Our Ref: 26/201106 [SSD-2025/1]
Our Contact: Harseerat Thind (02) 9562 1852

RE: Request for Advice – Response to Submissions – 49-61 Stephen Road, Banksmeadow – Multi-Level Warehouse

Thank you for the opportunity to provide comment on the Response to Submissions (RTS) for the proposed Stephen Road Multi-Level Warehouse at 49-61 Stephen Road, Banksmeadow (the site).

k)	Section 1 of the civil plans (drawing CO14950.01-SSDA460) contain the following errors:
a)	The storm filter chamber is shown to have a full height wall where a weir exists on the OSD tank plan. Another full height wall is shown next to the orifice wall where no such

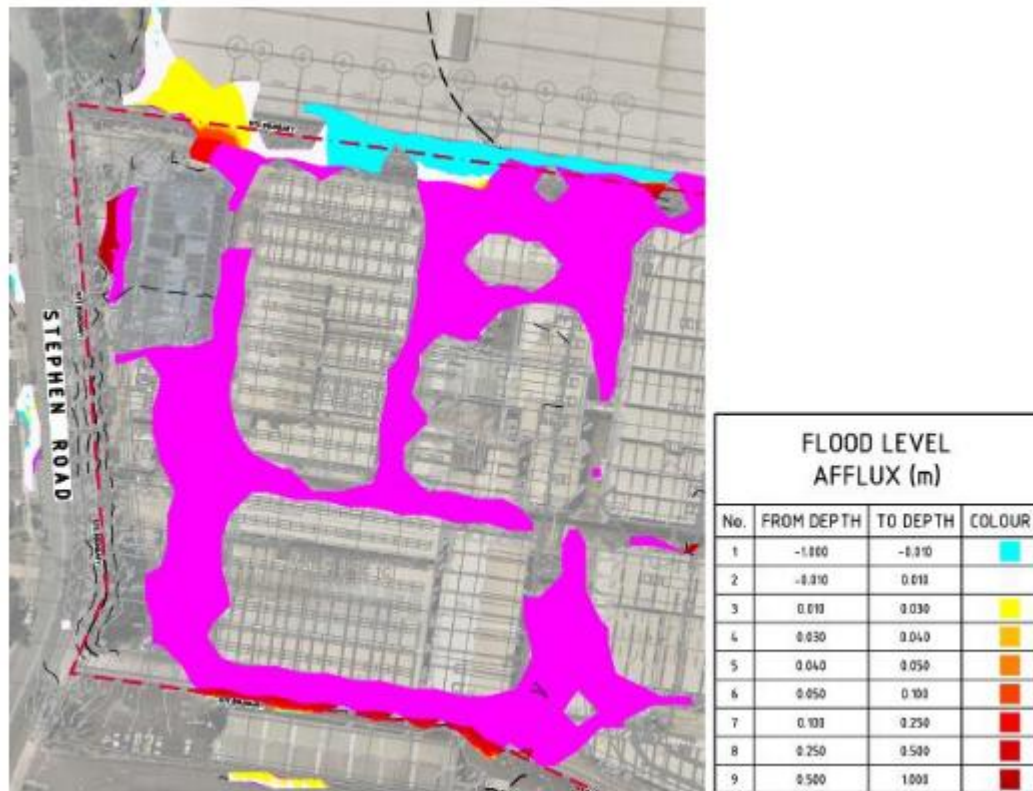
Council will not permit the site discharge connection into its Coal Pier Road drainage in the current configuration. This is because the development's discharge flows to Coal Pier Road exceed the capacity of the road drainage system, which does not comply with section 3.2.5 of Bayside Technical Specification Stormwater Management. It's also considered that the 1% AEP surcharge from pit D04 is excessive and unsafe and, the connection method of a 600mm pipe to 375mm pipe is not justified. This surcharge will have impacts on the operation of Coal Pier Road (due to localised flooding) which is not supported. Normally, a connection like this would warrant an upgrade to the downstream drainage (e.g. upgrading 375mm pipe to 600mm pipe in Coal Pier Road) however, it is not feasible to upgrade downstream drainage in this location. Therefore, to allow the OSD connection to Coal Pier Road, the peak 1% AEP flows/overflows from the OSD need to be reduced and the 600mm pipe between the OSD and pit D04 to be reduced to 375mm and surcharge to be reduced to not negatively impact the road. This requires further discharge control (i.e. further reduced orifice and enlarged OSD with reduced overflows) which has design impacts on the development.

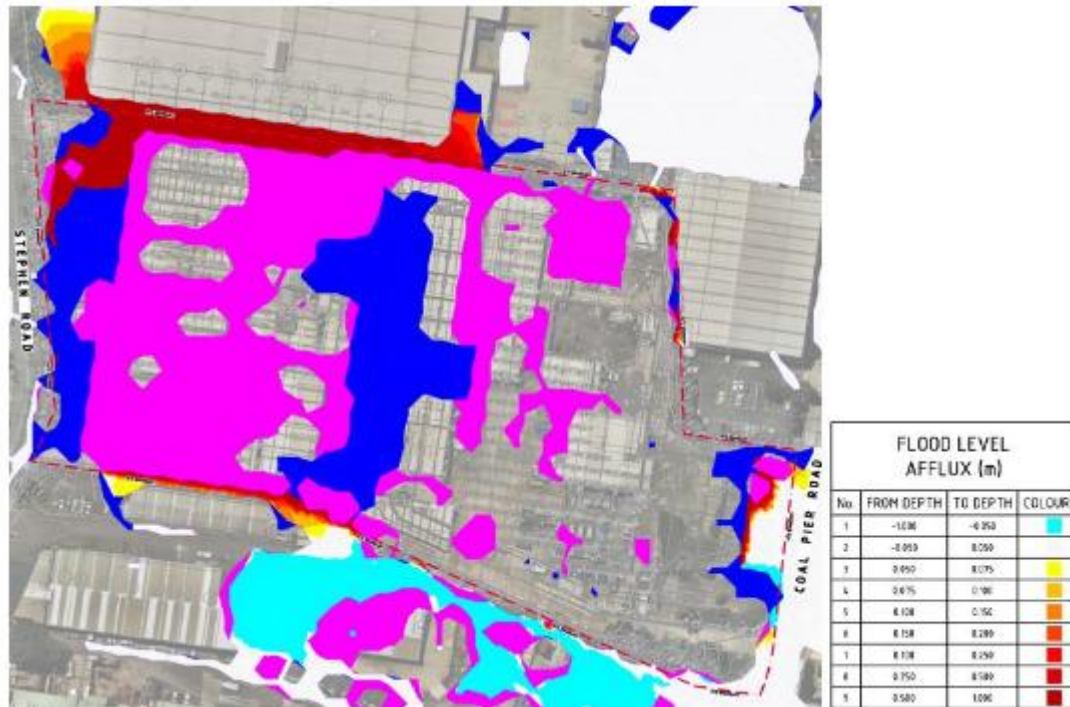
The revised flood modelling for the development continues to detail unacceptable flood impacts on neighbouring properties. The flood afflux mapping for the PMF with 1% AEP + sea level rise (SLR)/climate change (CC) flood events indicates non-compliant increase in flood levels (flood afflux) on the adjacent property to the north (28 Swinbourne Street). This is a direct consequence of the filling associated with the development which is blocking an existing flow path through the site from the northern property (28 Swinbourne Street). While the upstream catchment is relatively small, the modelling nevertheless identifies unacceptable increases in flood levels. The flow path still exists and must be maintained in the development to ensure no increase in flood levels on the northern property. The development needs to be revised to provide a flow path/flood storage along the northern boundary supported by revised flood modelling that demonstrates no increase in flood levels on neighbouring properties.

The proposed development is effectively transferring flood impacts onto the adjacent property in the climate change and the PMF event, which is inconsistent with key principles of the Floodplain Risk Management Manual (2023).
